Maxwell Project – SSD 9526 – Muswellbrook Shire Council Comment

I refer to the Environmental Impact Statement, prepared by Resource Strategies P/L for Maxwell Ventures (Management) P/L ("the Proponent"), for the Maxwell Project SSD - 9526. Council appreciates the opportunity for comment.

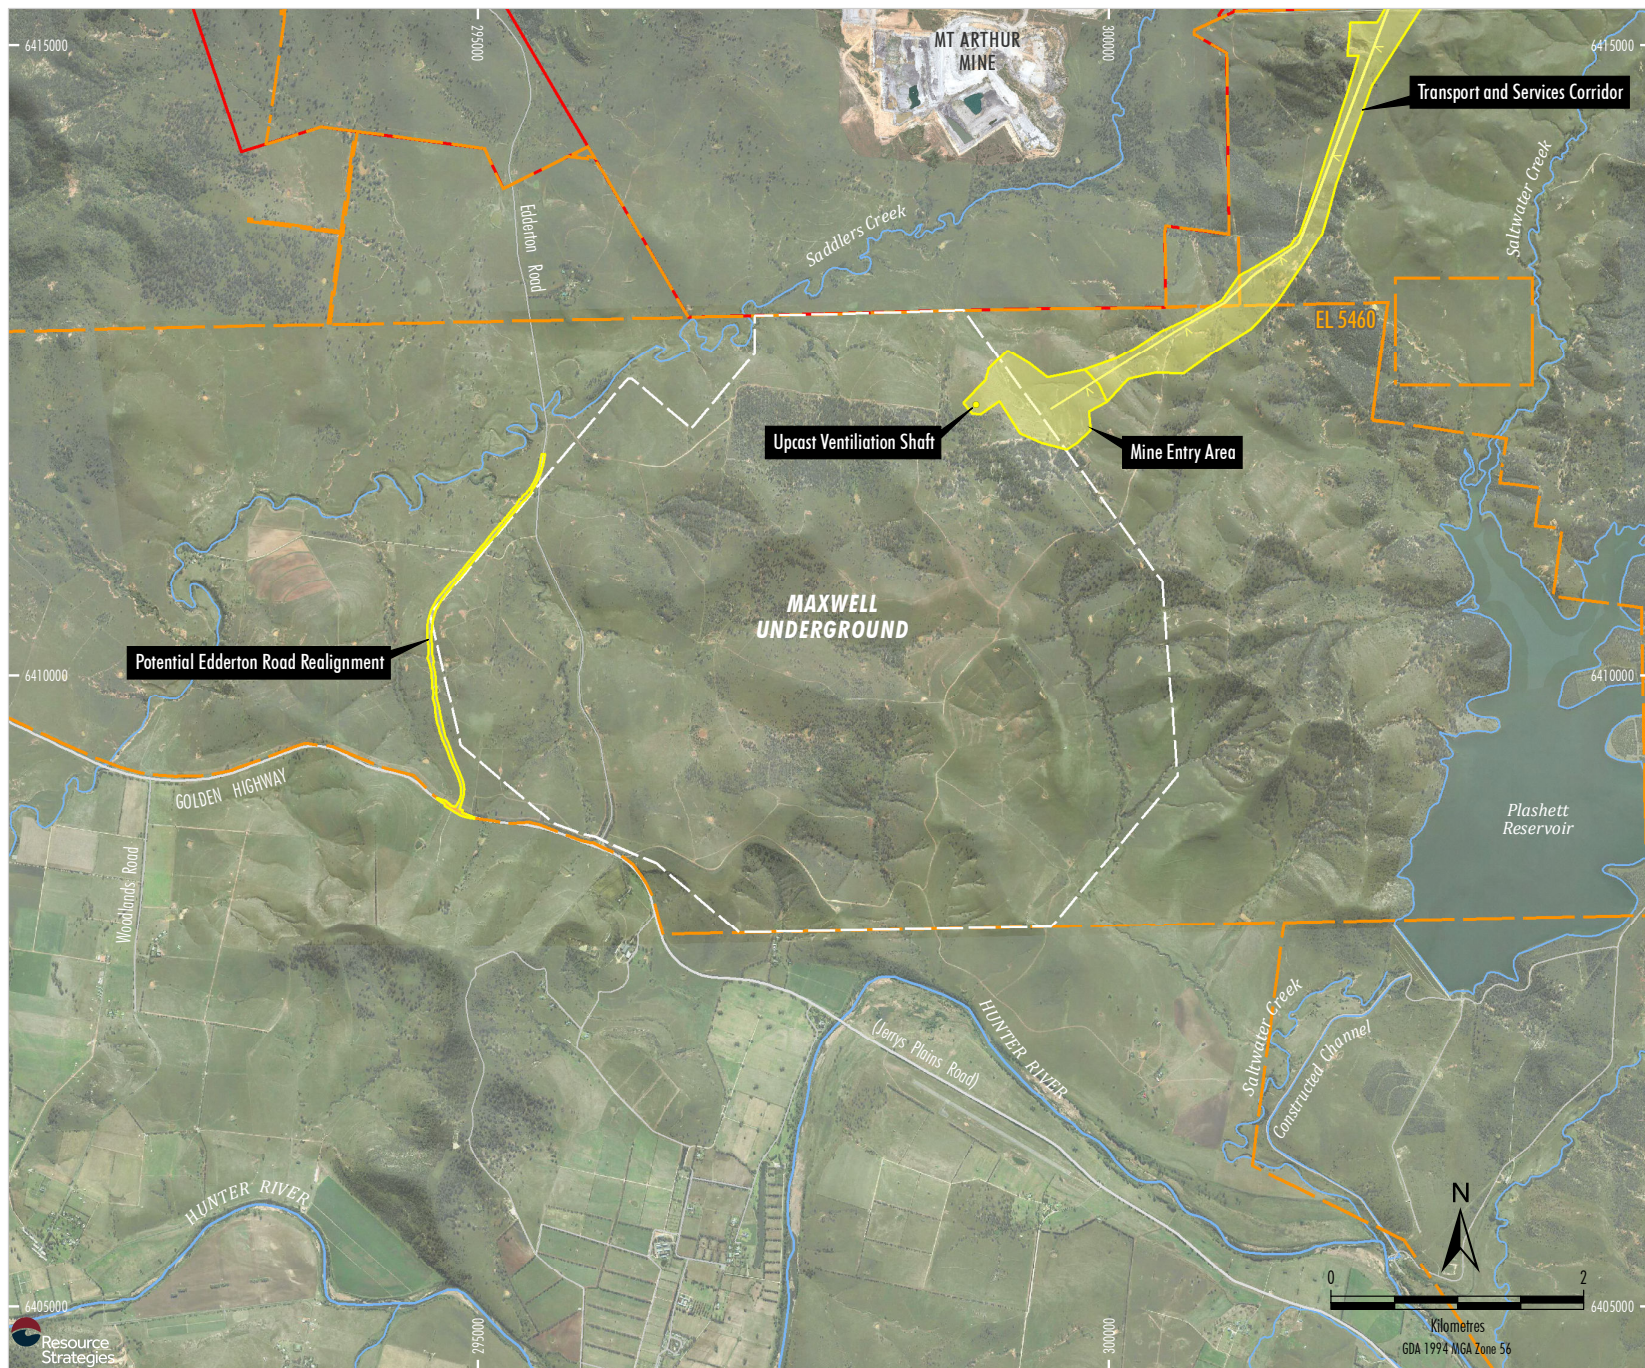
28.0 Figure 3-4 indicates that sealing of the site access road from Thomas Mitchell Drive to the Mine Entry Area would occur in the first year of mining operations. This means that construction vehicles and trucks transporting early ROM coal to the CHPP will travel over a gravel road. This will generate local dust and the use of water carts to suppress dust means local issues of salt accumulation and sediment/dust smothering adjoining plants. The access road needs to be sealed prior to construction and development of the Mine Entry Area, and definitely before any coarse rejects, tailings or early ROM coal is extracted from the Mine Entry Area.
